Medworth Energy from Waste Combined Heat and Power Facility

PINS ref. EN010110
Document Reference: Vol 9.20
Revision: 6.0
Deadline 6
July 2023

Schedule of Changes (Deadline 6)

**Figure 10.1i**  
**New Bridge Lane access design**

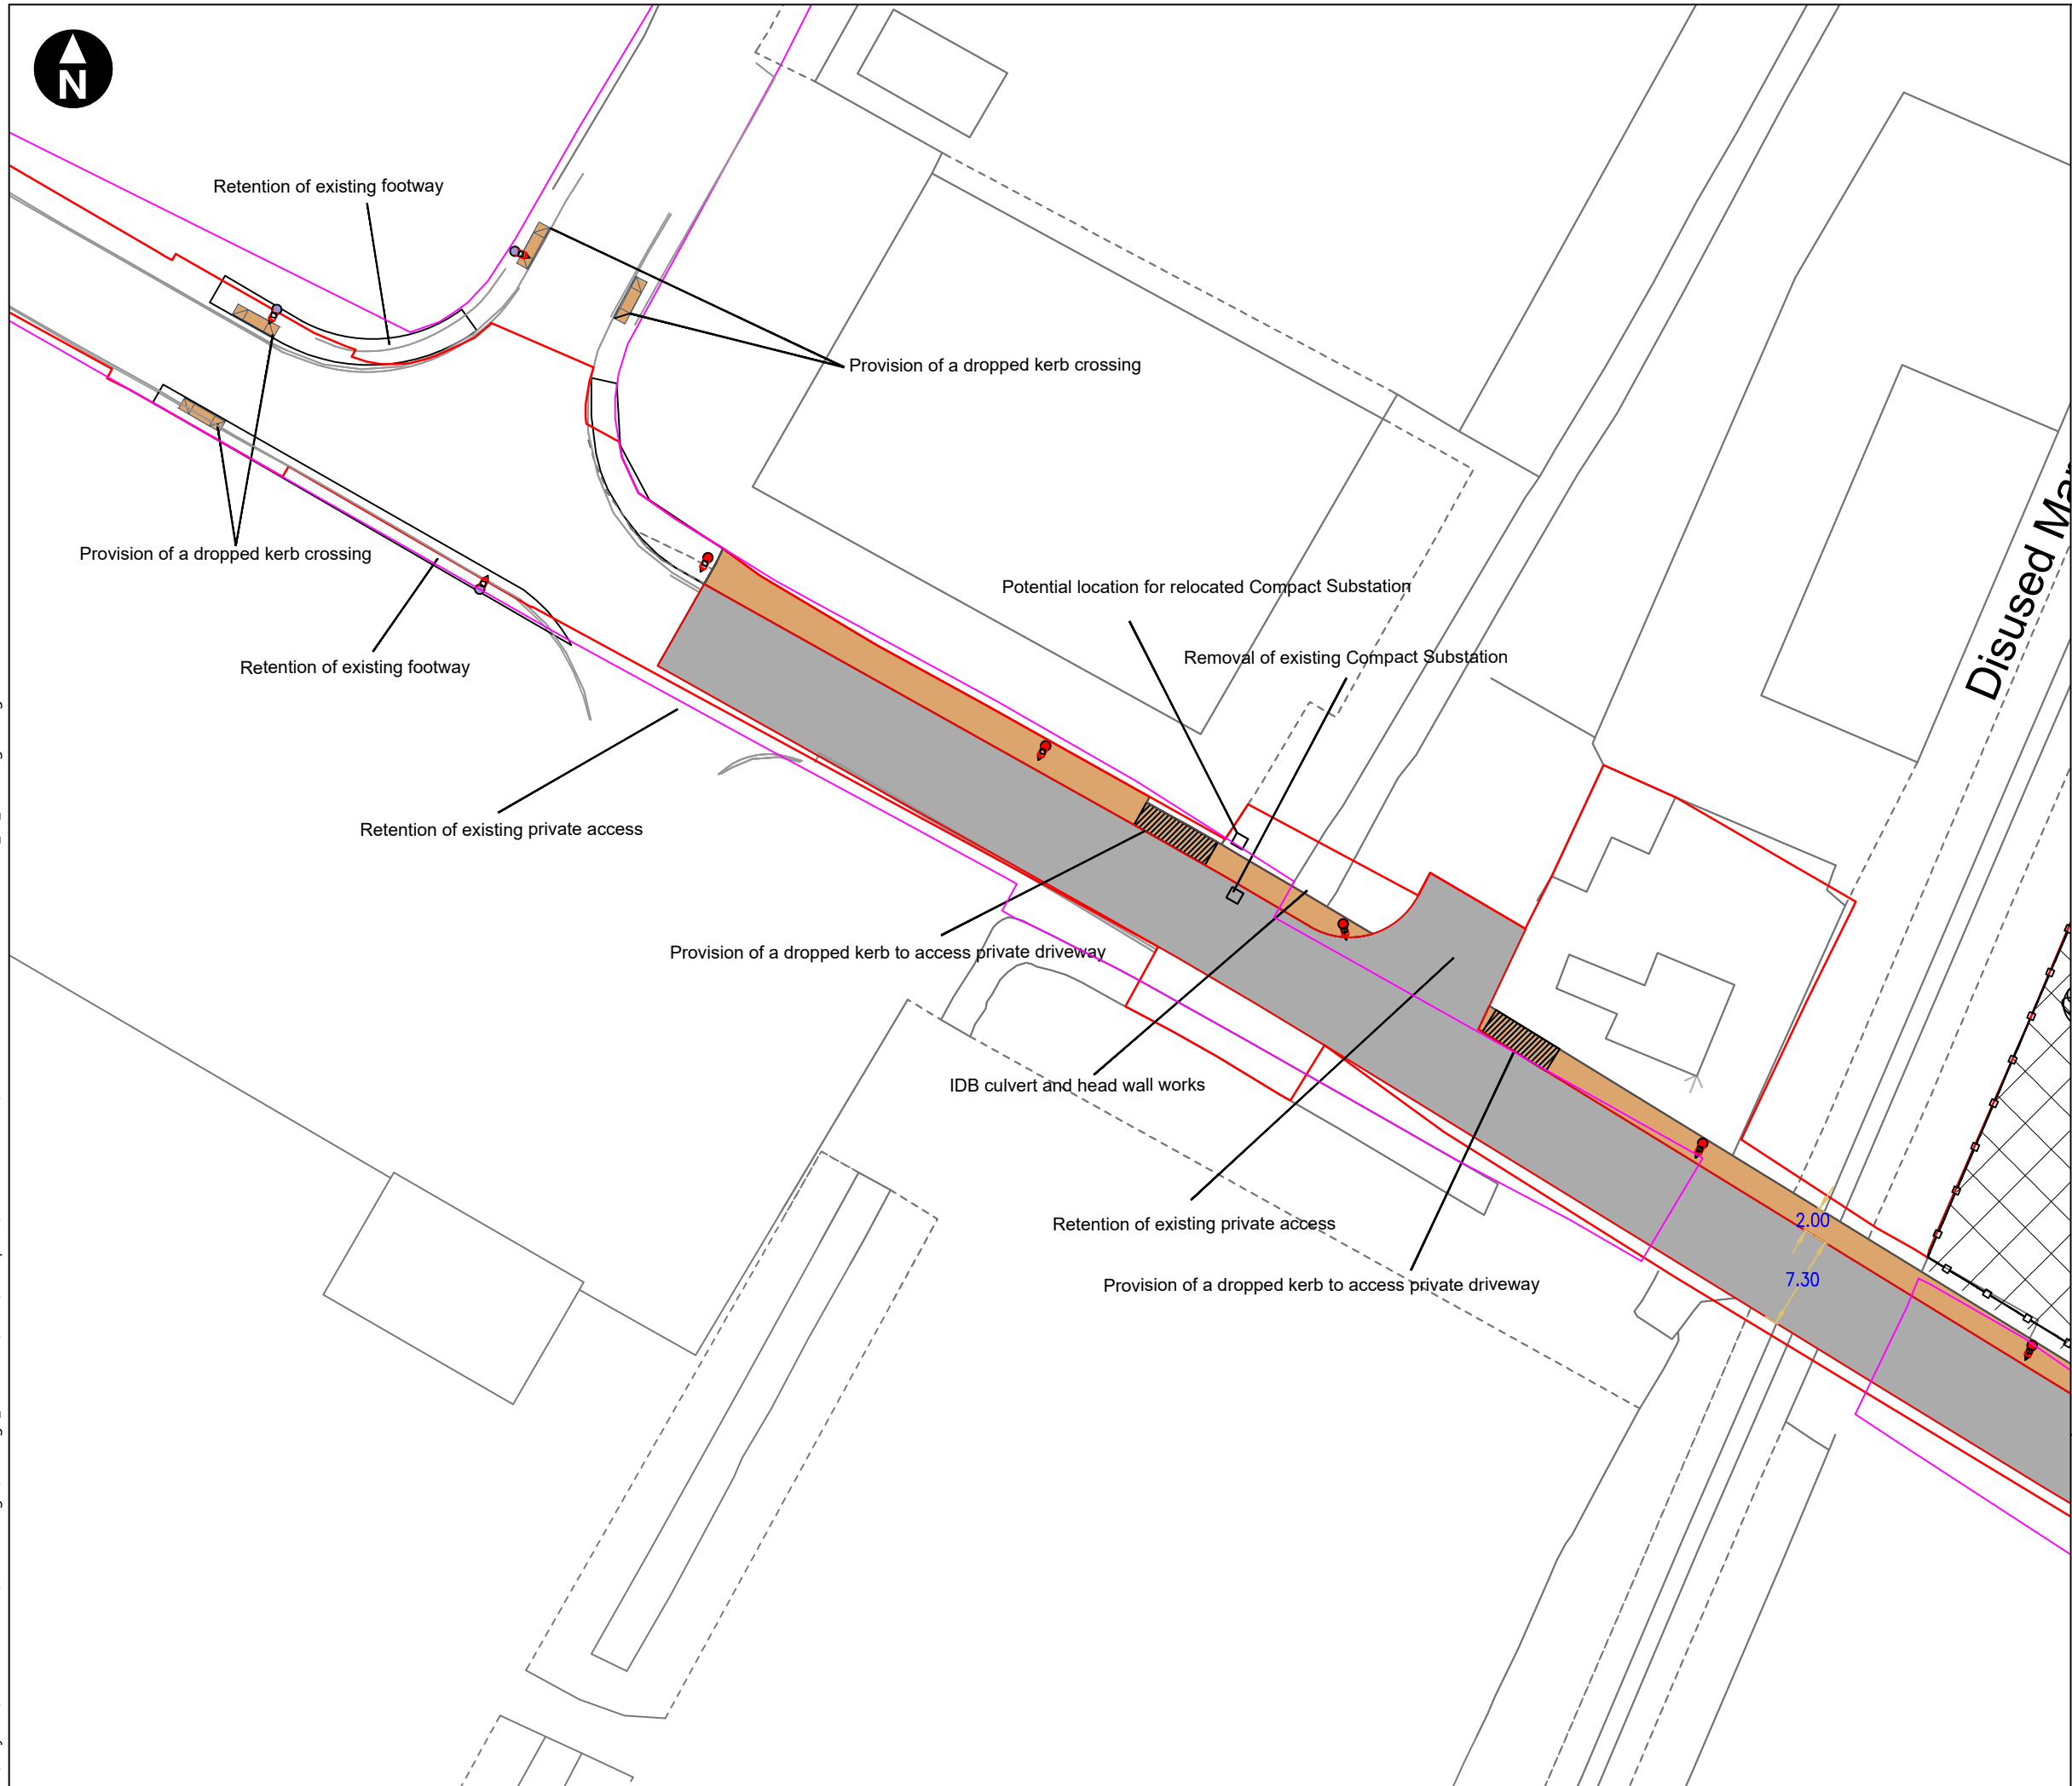
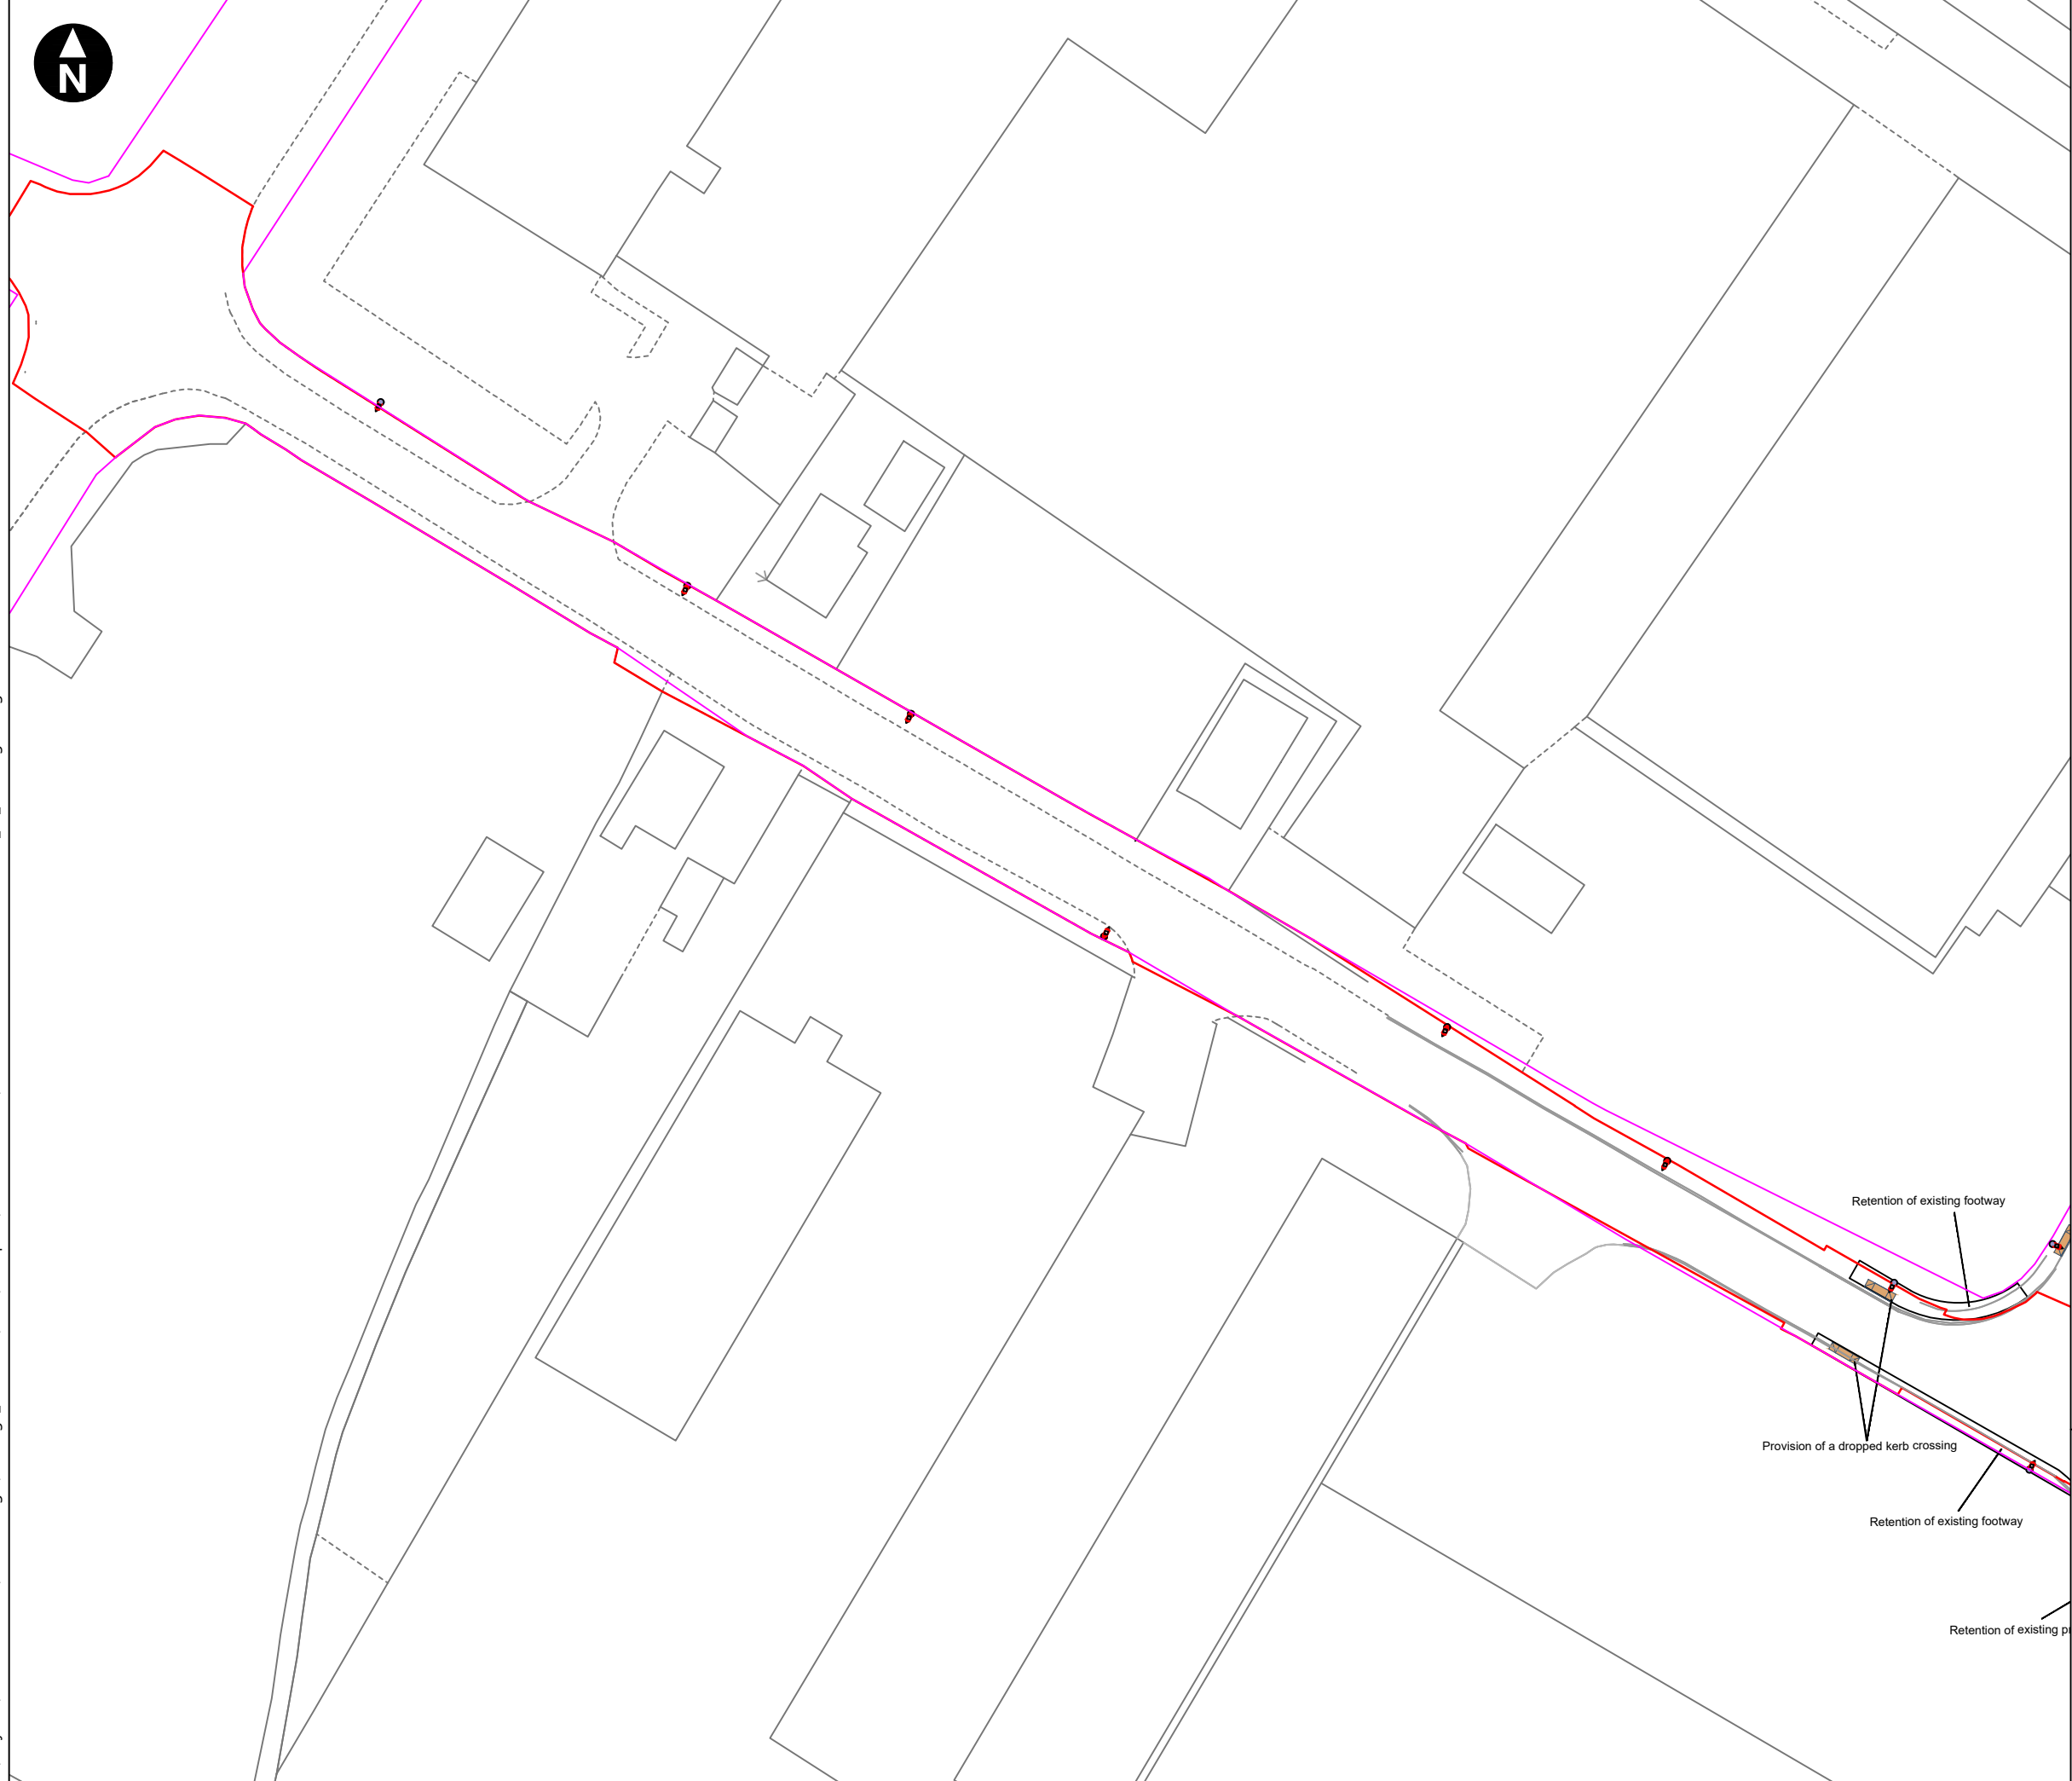
Document Updated	Change	Reason for change	Deadline submitted	Relevant Document version
and Transport Appendix 6A Outline (CTMP) [REP1-011]	Lane. Also Figure 10.3i – ii to show outline design for construction accesses into the CHP Connection Corridor from Weasenham Lane and accompanying swept path.			
Volume 6.4 ES Chapter 7 Noise and Vibration Appendix 7D Operational NMP [REP1-012]	Reference to Applicant's intention to purchase 9 New Bridge Lane updated to confirm that the property has been purchased. Additional text added to 5.1.2 to include for the submission of a report to the relevant planning authority detailing the height, materials and acoustic performance of the acoustic fence to 10 New Bridge Lane for agreement ahead of construction.	CCC and FDC Comments on the Applicant's D1 Submissions (Outline CEMP) [REP2-031]. Outline Operational Noise Management Plan.	Deadline 3	Rev 3
Volume 6.4 ES Chapter 7 Noise and Vibration Appendix 7D Operational NMP [REP1-012]	New paragraphs 1.4.8 and 1.4.9 to provide a commitment to the preparation of an Operational Noise and Vibration Management Plan for the Walsoken Substation.	KLWN Relevant Representation [REP2-028].	Deadline 3	Rev 3
